From:
To: [Planning Comments \(Shared Mailbox\)](#)
Subject: FW: Application 6/2019/3193/EM. 20 January 2020
Date: 20 January 2020 16:30:19

From:
Sent: 20 January 2020 16:26
To: James Homer <j.homer@welhat.gov.uk>
Subject: Application 6/2019/3193/EM. 20 January 2020

Project:	177 PARKWAY WGC.		
Drawing Title:	PROPOSED PLAN		
Drawn By:	ALI	Scale: 1:100	Date: Aug 20
Drg Status:	PLANNING		Checked:
Drawing No :	4794-P01	Revision:	E

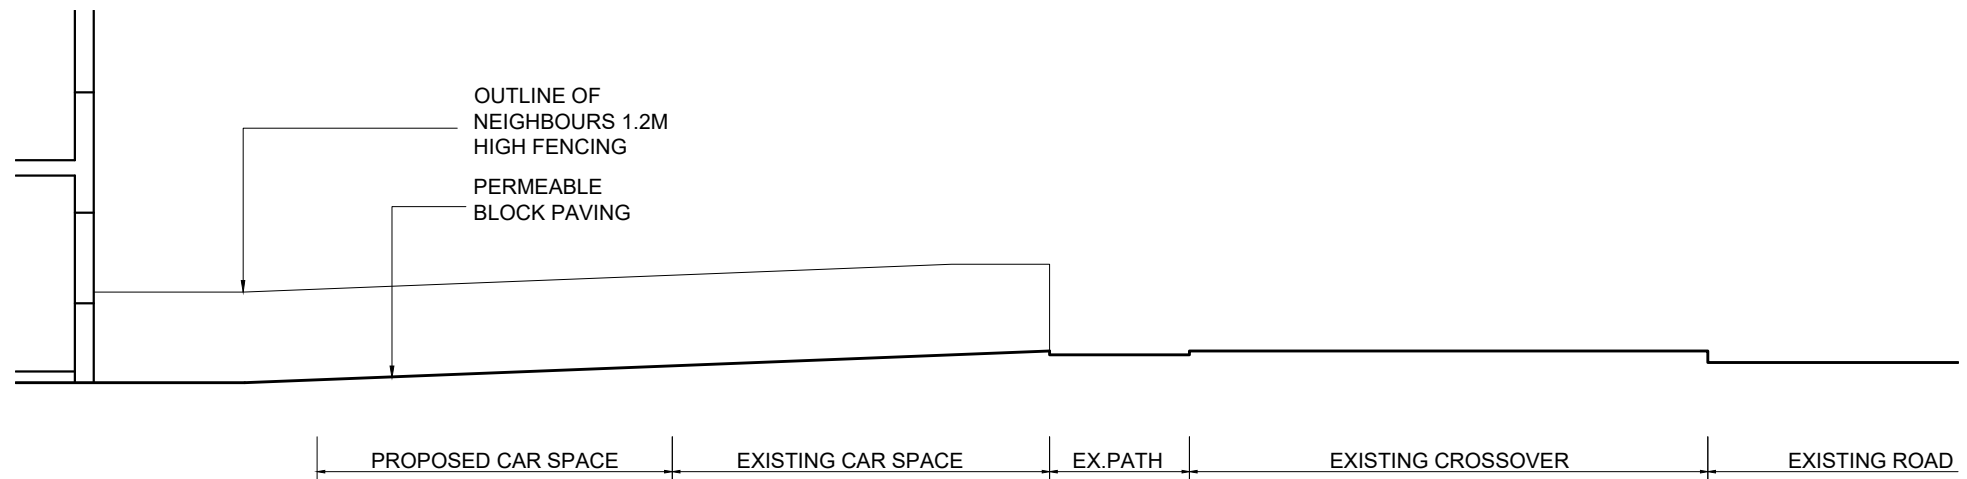
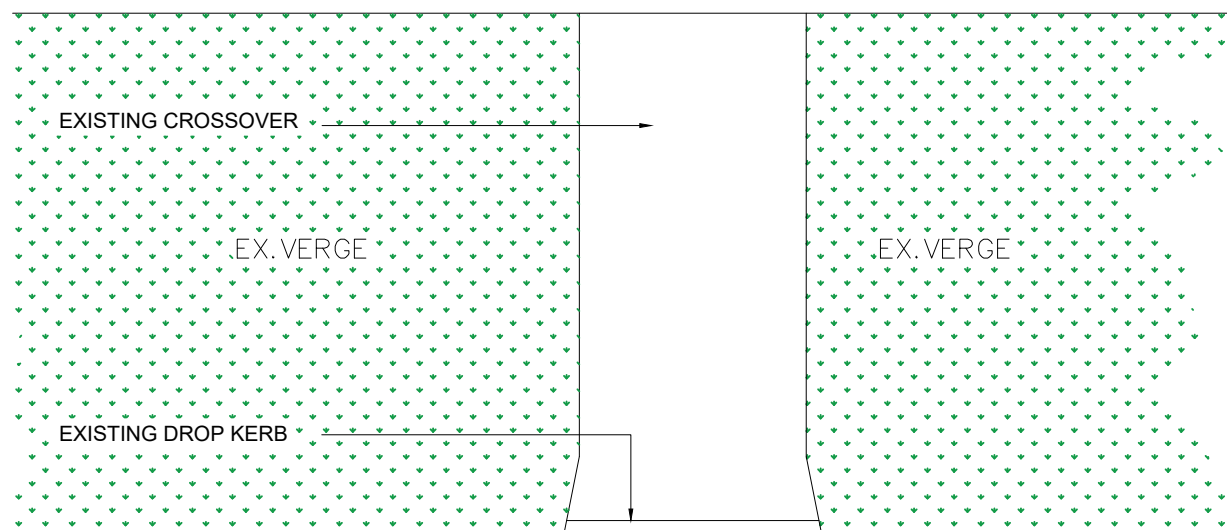
My objection to this application is in respect to the previous application 6/2019/2208/EM which was refused by the Estate Management Scheme for various documented reasons. It would appear that an apparent disregard of that outcome is occurring, as the new proposed application for the hardstanding schedule of area is the same as the previous proposed plan which was refused by the EMS. The latest application shows no sign of the boundary hedge between 177 and 179 Parkway on the proposed plan, unless there has been an oversight on the new proposed plan. An objection is therefore necessary as no justifiable cause has been given within the application to remove the boundary hedge, however the proposed plan does indicate a return of the hedge on the right hand side that is currently missing, on the highways land. Further clarity is required within this application as the current proposed plan does not ensure that there is 50% minimum, of the frontage soft green landscape retained, as required by the EMS, to ensure the garden city maintains its unique character.
